Immingham Green Energy Terminal

9.41 Applicant's Comments on D1 Submissions from
Natural England

March 2024

Document Reference: TR030008/EXAM/9.41

Plate 1: Location of compensation site at OtSMRS in relation to the Project

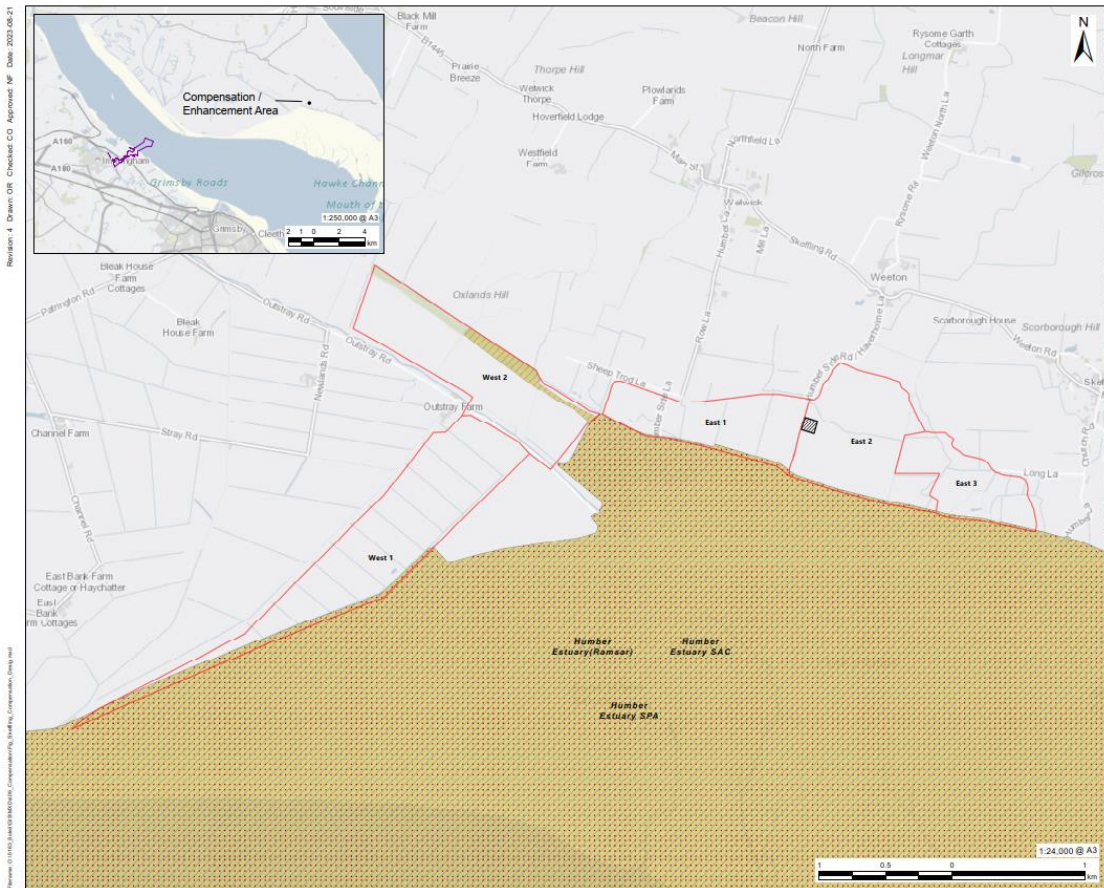
Question	Interested Party's Response
<p>Compensatory Measures</p> <p>Does NE consider that the Applicant's proposed compensatory measures, presented in [APP-235, Section 4], would be sufficient to deal with the scale of potential harm to European Sites?</p>	<p>Natural England advises that the suitability of the proposed compensatory measures cannot be determined until the impacts from the project have been assessed in more detail and it has been determined whether the proposed mitigation will be sufficient. Natural England does not consider there to be a 'typical' ratio for compensatory habitat provision where there has been loss from marine protected sites, as it is necessary for uncertainties with compensatory measures to be reflected in the scale of compensation delivered. However, in this case we agree that 3:1 is appropriate. We acknowledge that the compensation would be delivered outwith the IGET project due to OtSMRS being</p>

<p>subject to a separate pre-existing consent. However, we consider it would be appropriate for the Applicant to be required to submit confirmation demonstrating compensation delivery once the habitat has been established. Natural England note that the proposed compensatory measures do not currently include measures for other impacts, for example bird disturbance. Clarity is required regarding whether the compensatory measures would be appropriate, in the event that a conclusion of no adverse effect on integrity cannot be reached, or whether additional compensatory measures would be required.</p>
<p>Applicant's Comment</p>	
<p>A Without Prejudice Report to Inform HRA Derogation was submitted as part of the application [APP-235] and updated at Deadline 1 [REP1-008]. This report identified the Outstrays to Skeffling Managed Realignment Scheme ("OtSMRS") as a means to provide compensation for intertidal habitat loss on a without prejudice basis should this be required. The Applicant remains confident that all other pathways, including bird disturbance, can be effectively mitigated, and as such will not result in an Adverse Effect On Integrity, thereby negating the need for compensation.</p>
